From: Kevin Eaton <[REDACTED]>
Sent: 07 April 2021 12:58
To: Planning.Responses <[REDACTED]>
Subject: Fw: Request for further information K/12/21/NMA

The specific changes to windows sizes and locations are outlined below with justification:

Proposed Elevations

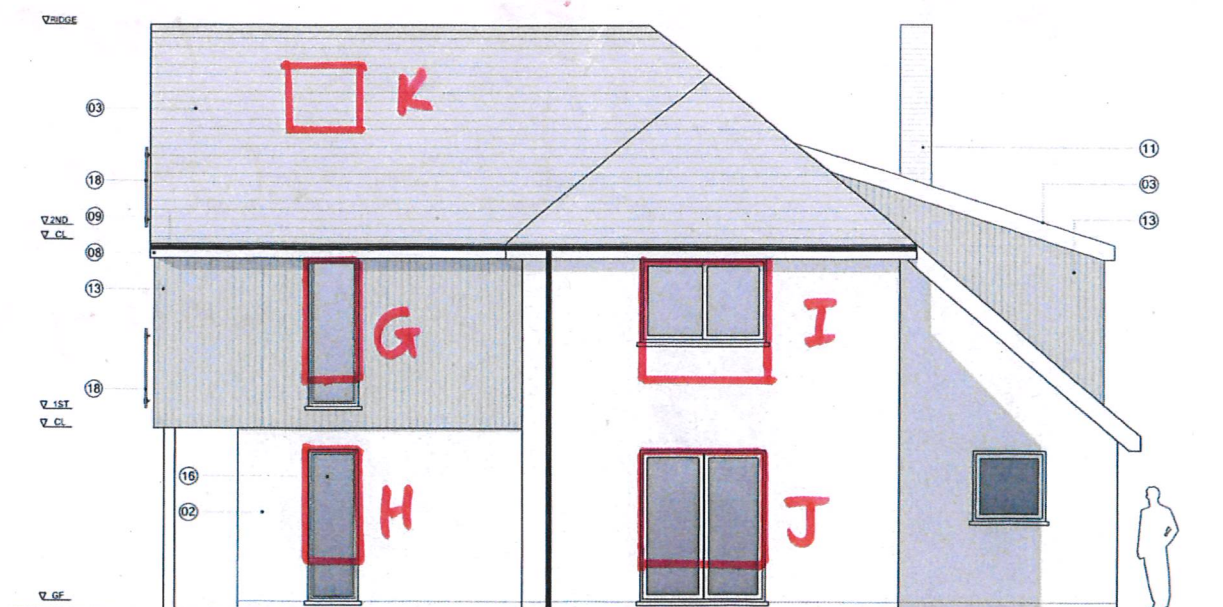
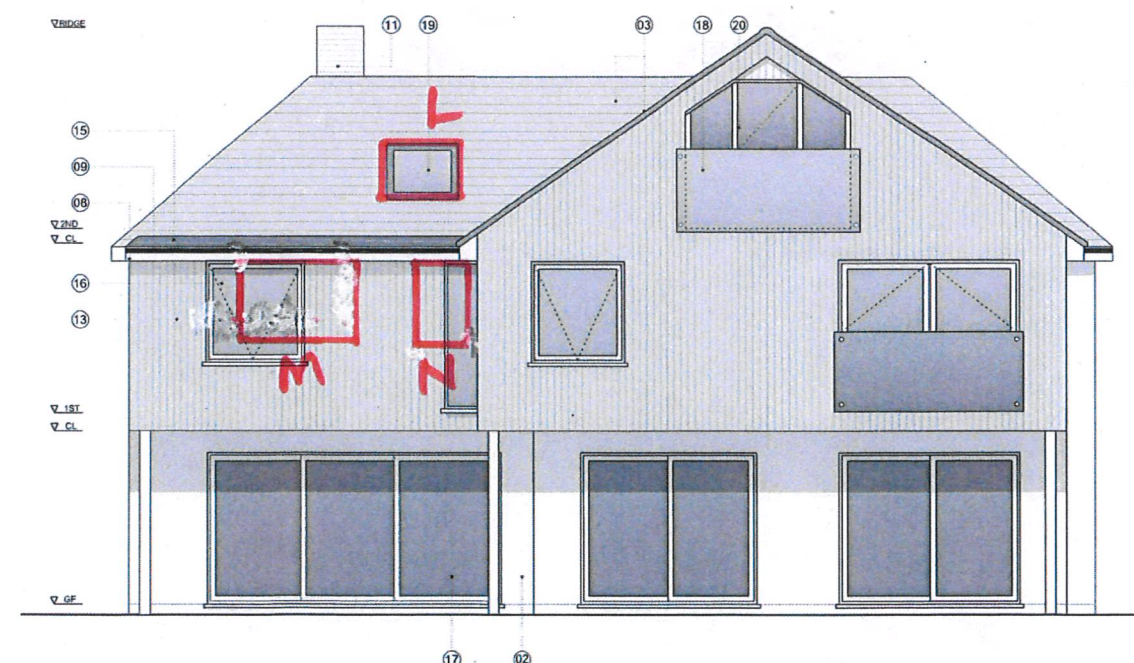
A - Retain as currently is - cost saving measure to remove proposed sliding patio doors to GF west elevation from lounge.

B - Reduction of north facing window height - Cost saving + Privacy enhancement to neighbouring properties - this is a first floor landing area with no specific requirement to overlook to north of property. Suggested change will reduce overlooking to properties to the north whilst also reducing window costs.

C - Reduce in size from that agreed - Cost saving and aesthetic enhancement.

D - Change of position of window and increase in number from one to 2 from that agreed. To enhance views over open countryside to the east without impacting on neighbours.

E - Reduce in size from existing bedroom window. To accommodate internal changes and wall locations.

F - Reduce in size from that agreed - Cost saving and aesthetic enhancement.

G - Addition of window to bathroom. Omitted by mistake during original application. Required to introduce fresh air to bathroom. This proposed window is east facing over open countryside and will not look directly over neighbouring property (The Moorings) to the north.

H - Reduction in width and increase in length - net reduction in window size - To accommodate internal changes.

I - Removal of window to North facing elevation - Cost saving

J - Retain as currently is - cost saving measure to remove proposed sliding patio doors to GF north elevation from dining room.

K - Addition of window to bathroom. Omitted by mistake during original application.
